***MODIFICATION REQUEST:  
Sydney University Abercrombie  
Precinct Redevelopment  
Cnr Codrington Street and Abercrombie  
Street  
(MP07\_0158 MOD 3)***

- Modification to the Student Accommodation Building

Director-General's  
Environmental Assessment Report  
Section 75W of the  
*Environmental Planning and Assessment Act*  
1979

February 2014

Title
Scale
Date
Number
0 2 4
10 20m
Sections
1:500/1:100/1:50@A1
06.02.14
4001_DA07-F
© copyright nettletontribe partnership pty ltd

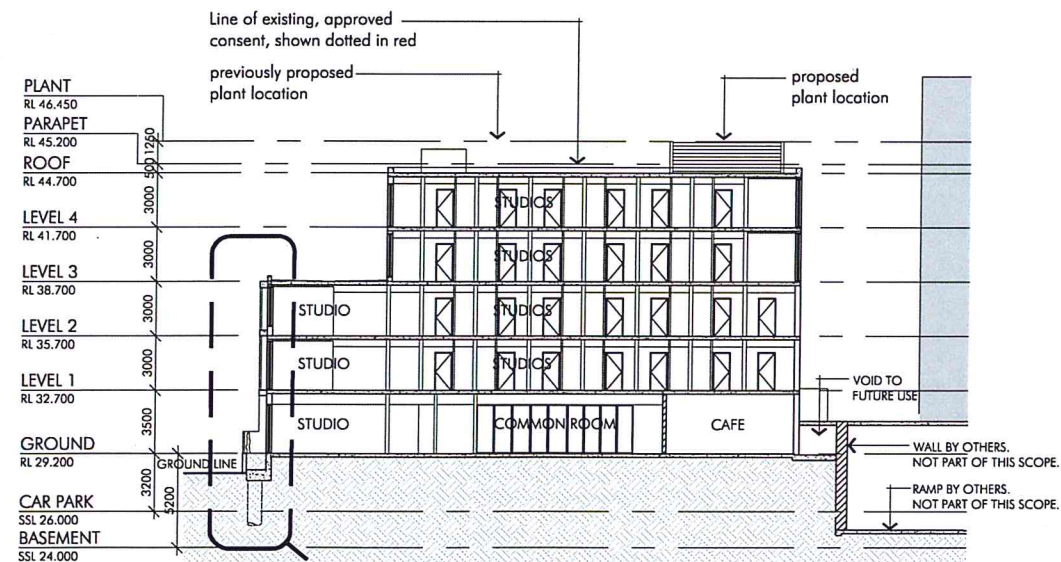
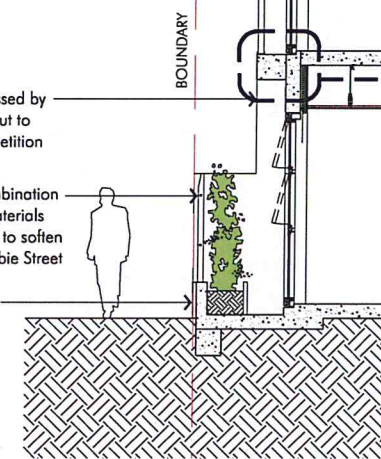
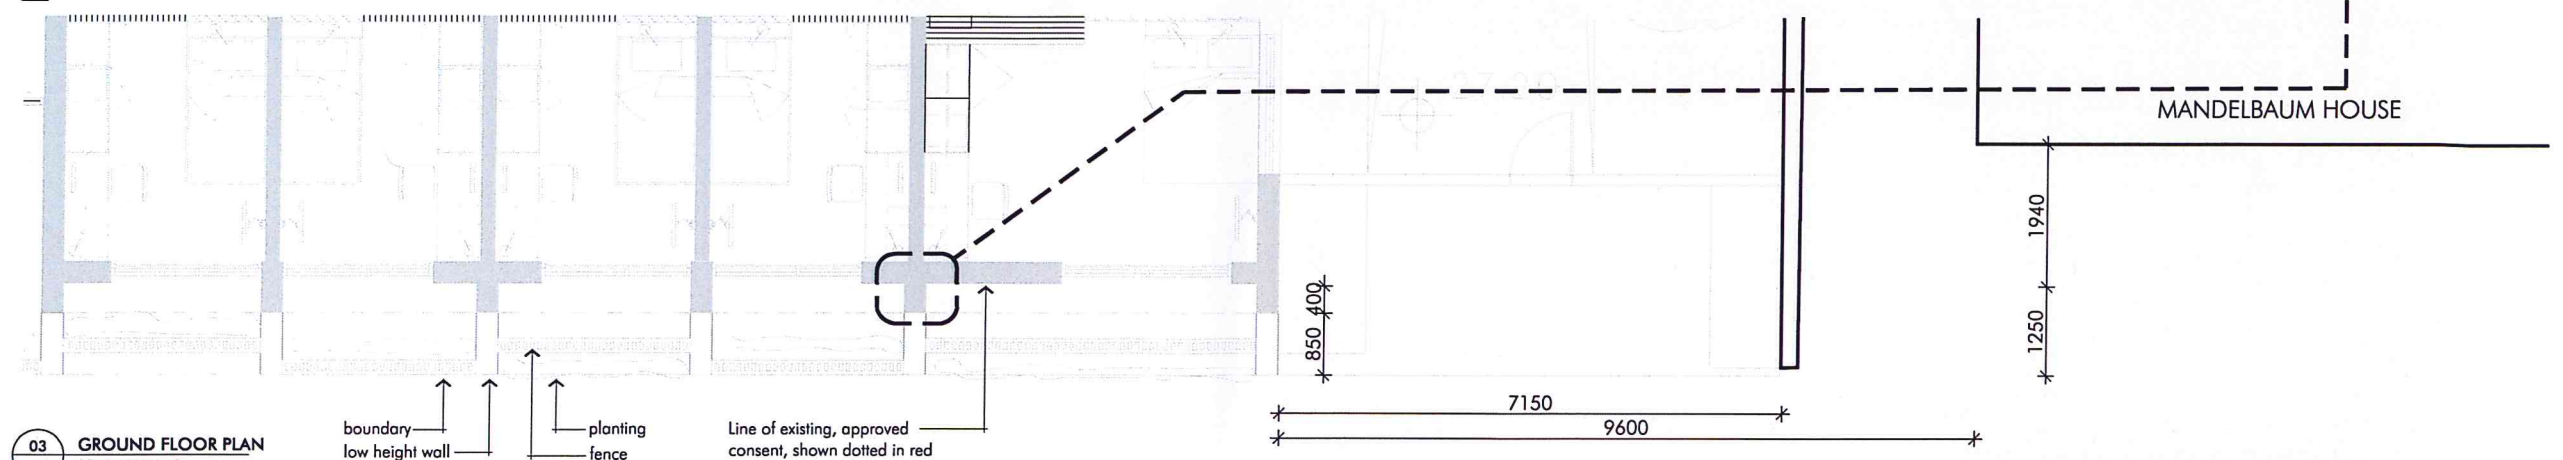
- the interface between the Abercrombie Street public footway and private realm needs to be improved;
- the proposed front timber fence sited on top of the front retaining wall is not supported as it will negatively impact on the quality of the streetscape;

Proposed front fencing details indicate timber batten and sandstone wall fencing ranging in height between 1.8 m to 2.2 m. As detailed in Section 04 of **Figure 12**, the top level of the timber battens remains constant, while Section 05 details the height of the sandstone wall increasing to compensate for the site's approximate 1.8 m downward slope along the Abercrombie Street frontage (see **Figure 12** and **13**). Vegetation is also proposed with the timber batten fencing in an alternating pattern (see **Figure 14**) to break up the fencing line and add variety to the frontage.

While council advised that the timber batten and sandstone wall fencing arrangement provides an improved relationship to Abercrombie Street, it also noted that the relationship between the building, fencing, walls and landscaping created an inactive frontage and reduced passive surveillance opportunities. Concern was also raised with respect to the maintenance of the proposed vegetation integrated into the fencing due to limited access.

In response, the proponent notes that the fencing has been provided to create a residential character along the site's frontage, whilst still permitting visual permeability. The department considers the proposed fencing along the site's frontage to be satisfactory in providing security for the occupants of the development. It also offers a design response that reflects the non-institutional character of the local area. With respect to council's concerns regarding the lack of passive surveillance, the department notes that single bed studios are proposed predominantly along the ground floor, to which a level of vegetation and screening for privacy should ideally be provided. Notwithstanding, the permeable nature of the proposed fencing will ensure passive surveillance is possible when the rooms are occupied. Further, Levels 1 and 2 will also have single studios fronting Abercrombie Street, which will also provide casual surveillance to enhance the sense of safety and security.
